**From:** Contact Centre (CRM) <contact@ribblevalley.gov.uk>  
**Sent:** 14 February 2024 13:10  
**To:** Planning  
**Subject:** Planning Application Comments - 3/2022/0841 FS-Case-586778312

**Planning Application Reference No.:** 3/2022/0841

**Address of Development:** Greystones  
Dinckley  
Blackburn  
BB6 8AN

Title: Site Plan & Viewpoints

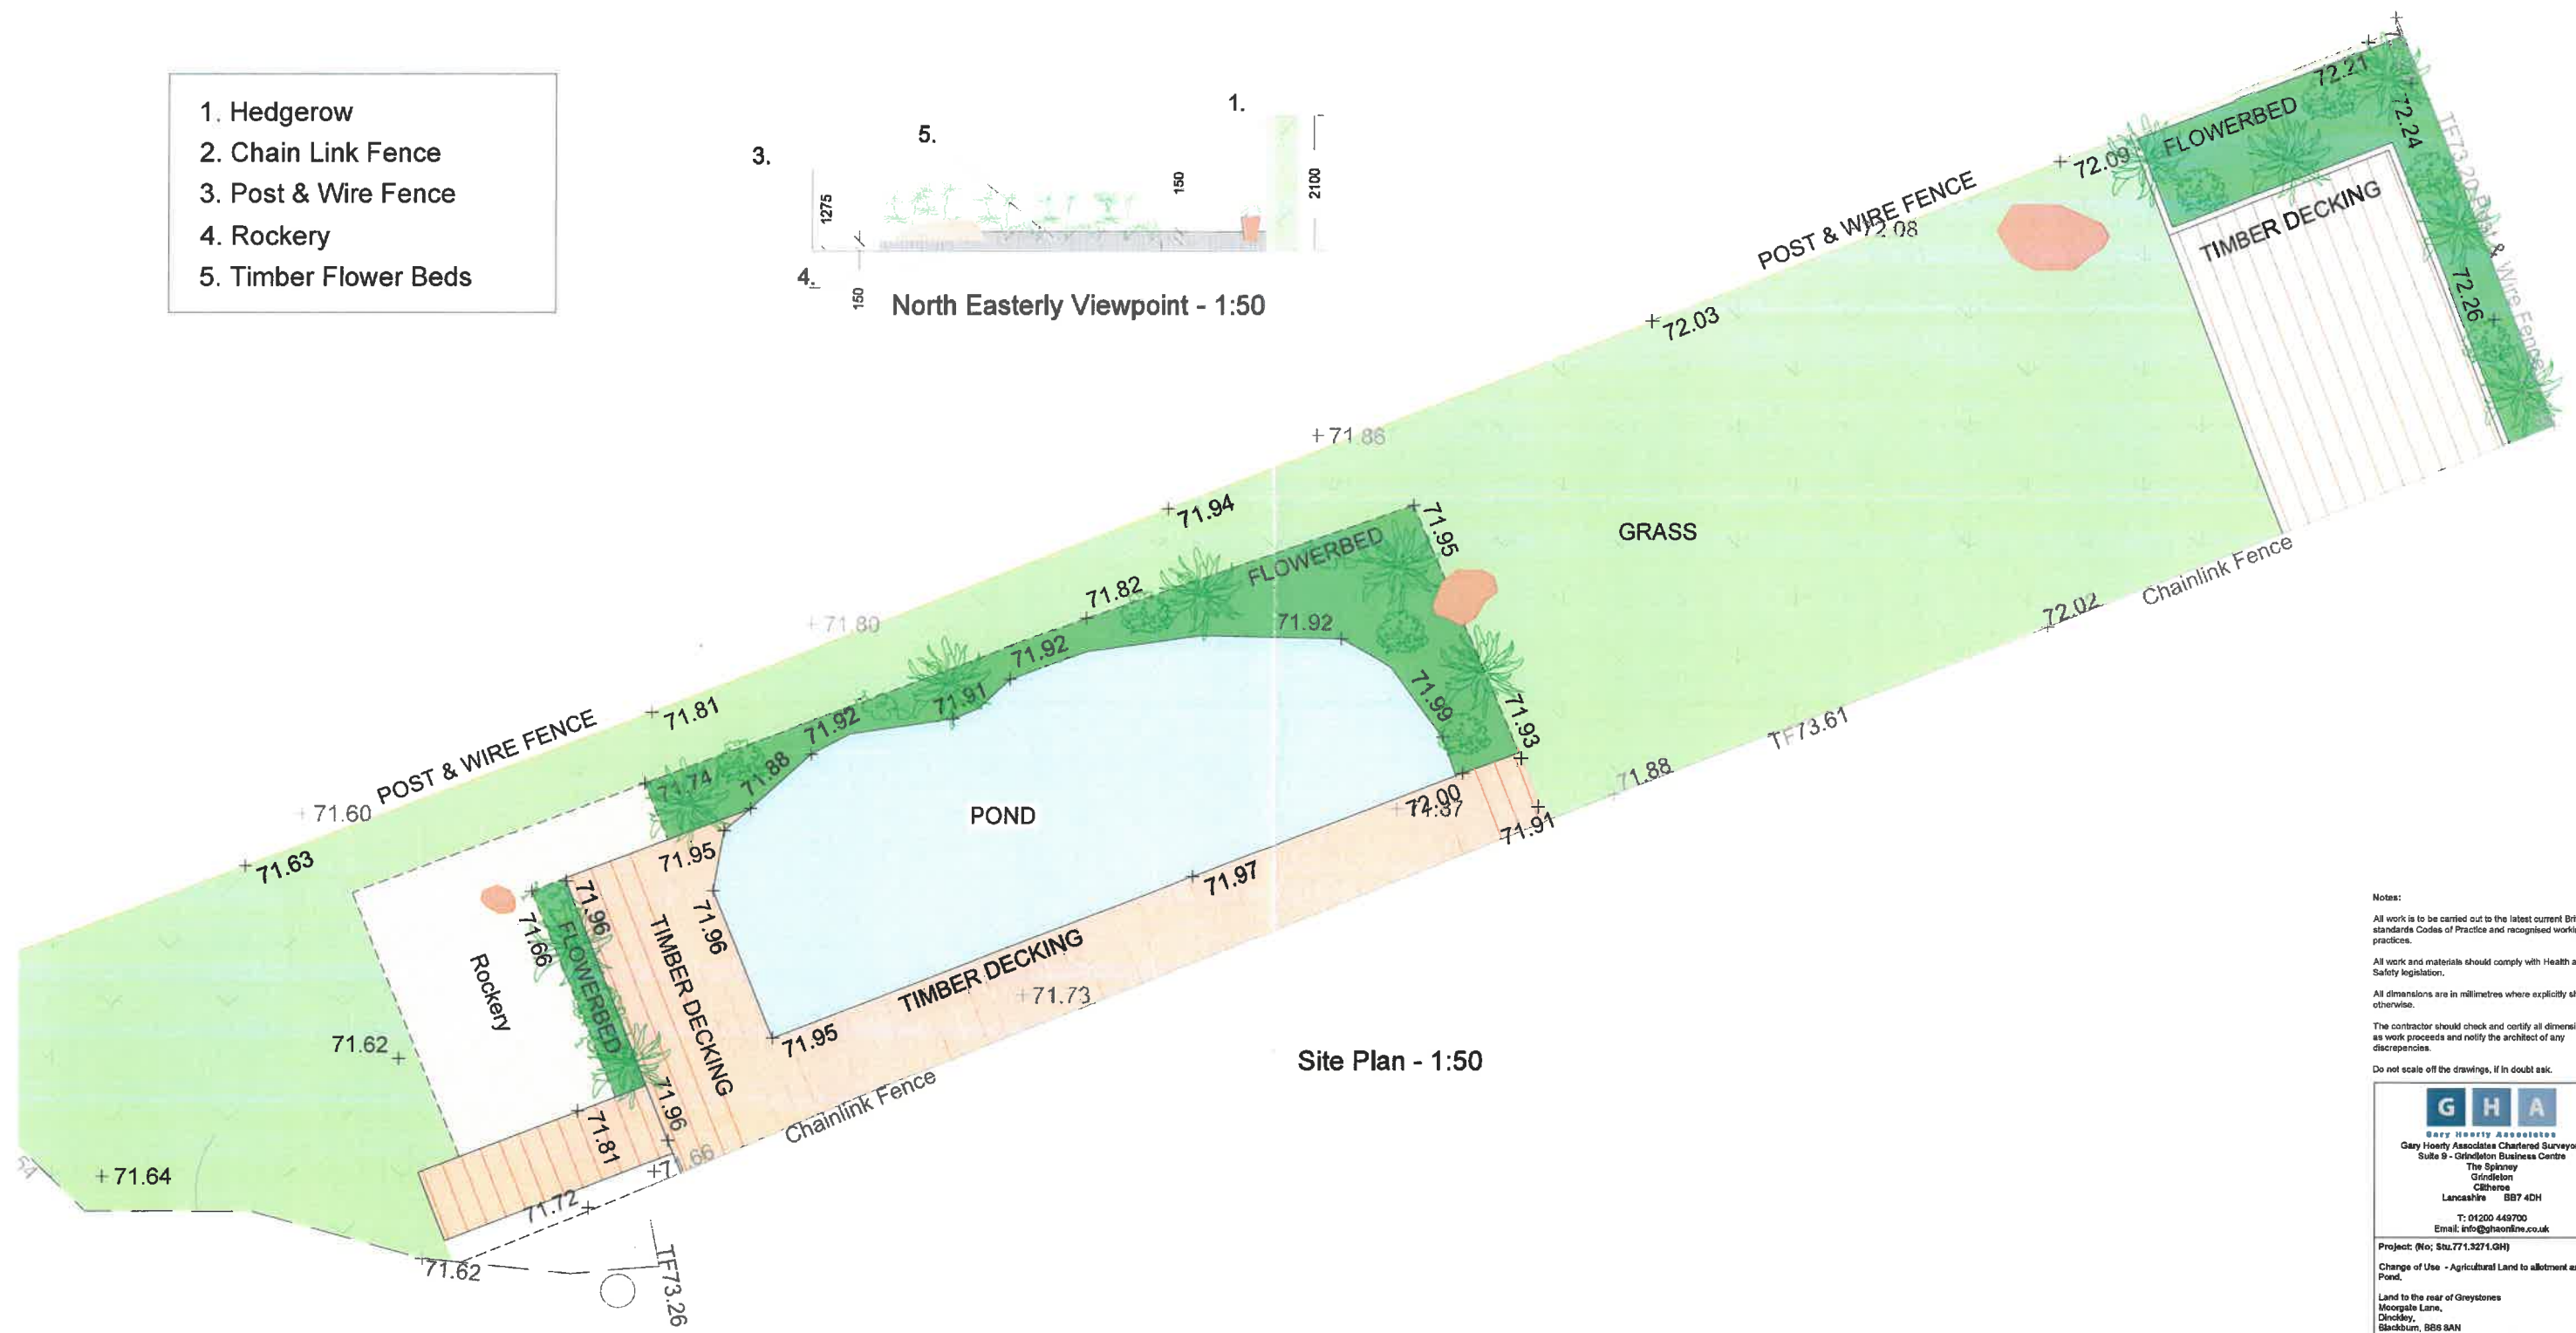
My first response is just to say that the Existing Site Plan 22 0841 has incorrect information. The area labelled Allotment for Greystones by the swimming pool area is incorrect. Greystones does not own this land or operate an allotment. I believe it is part of Merlewood.
